Our Ref: P/90/11/

14th November 2011

First floor balcony to owners leisure and relaxation facility & enlargement of garden amenity space

Church Farm Holiday Village Church Lane Pagham

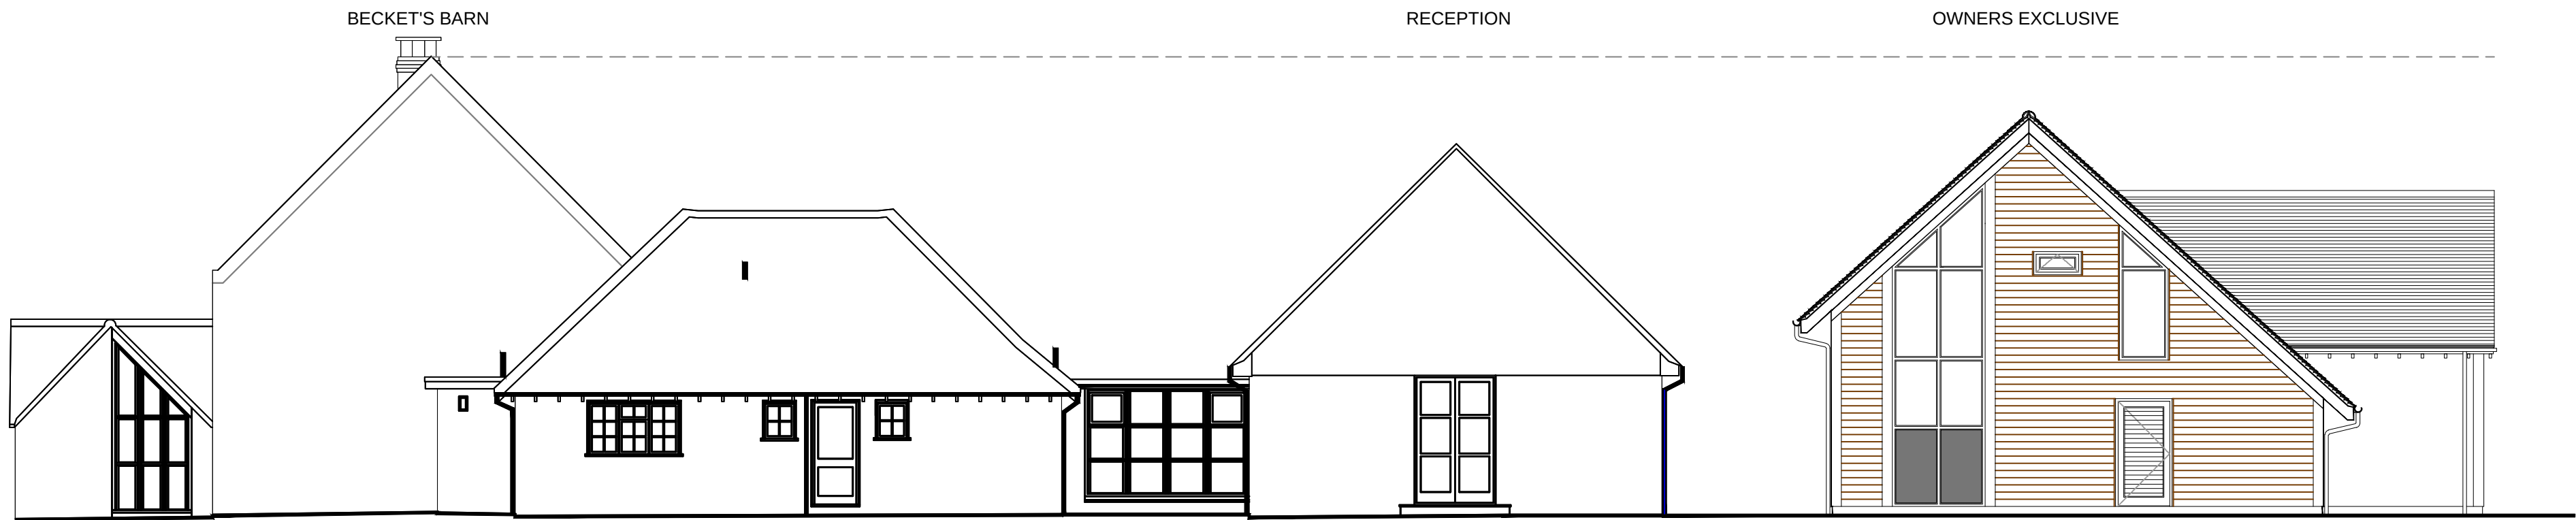
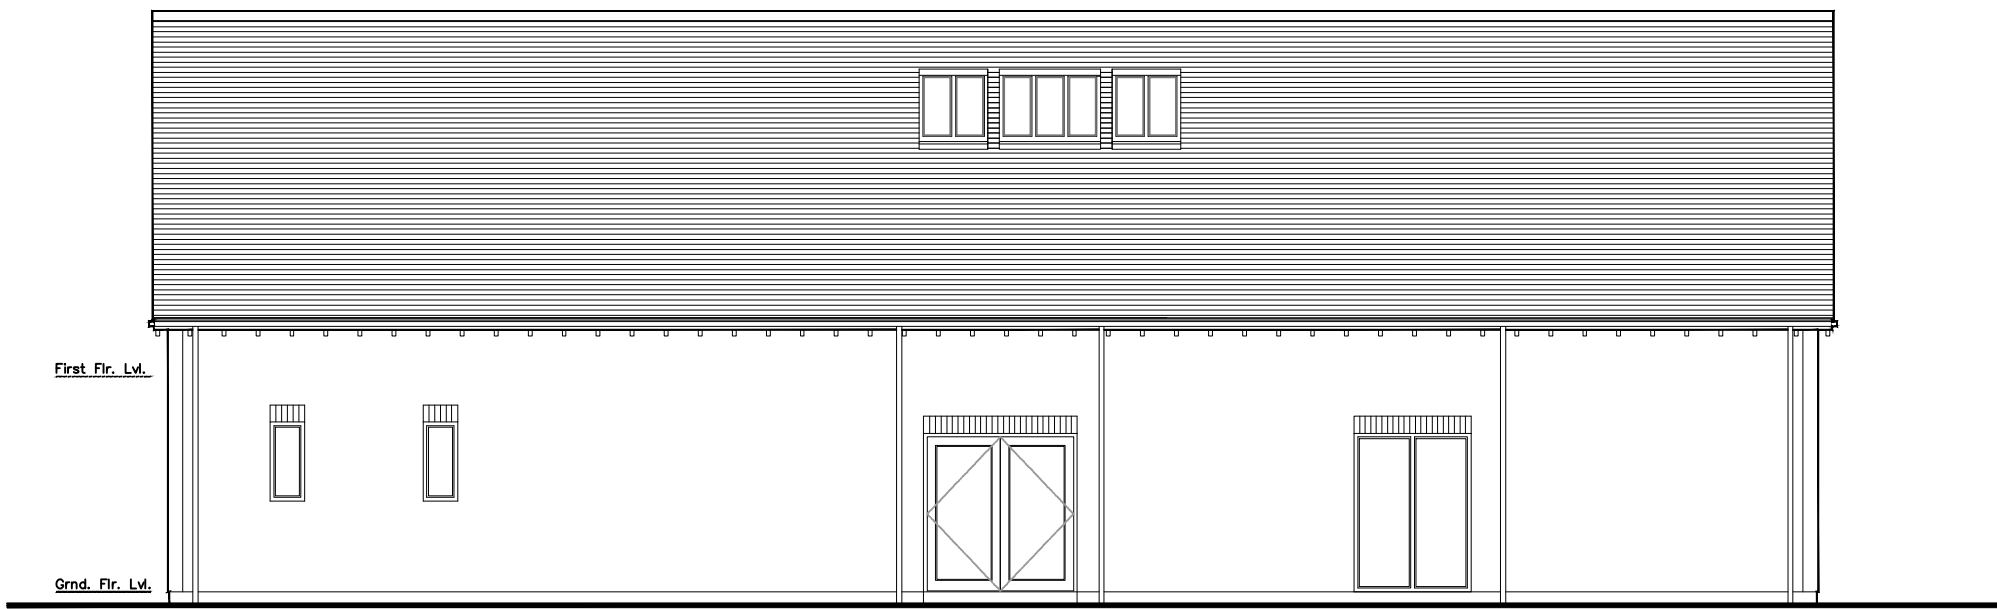
Please provide elevations to show the proposed boundary treatment.
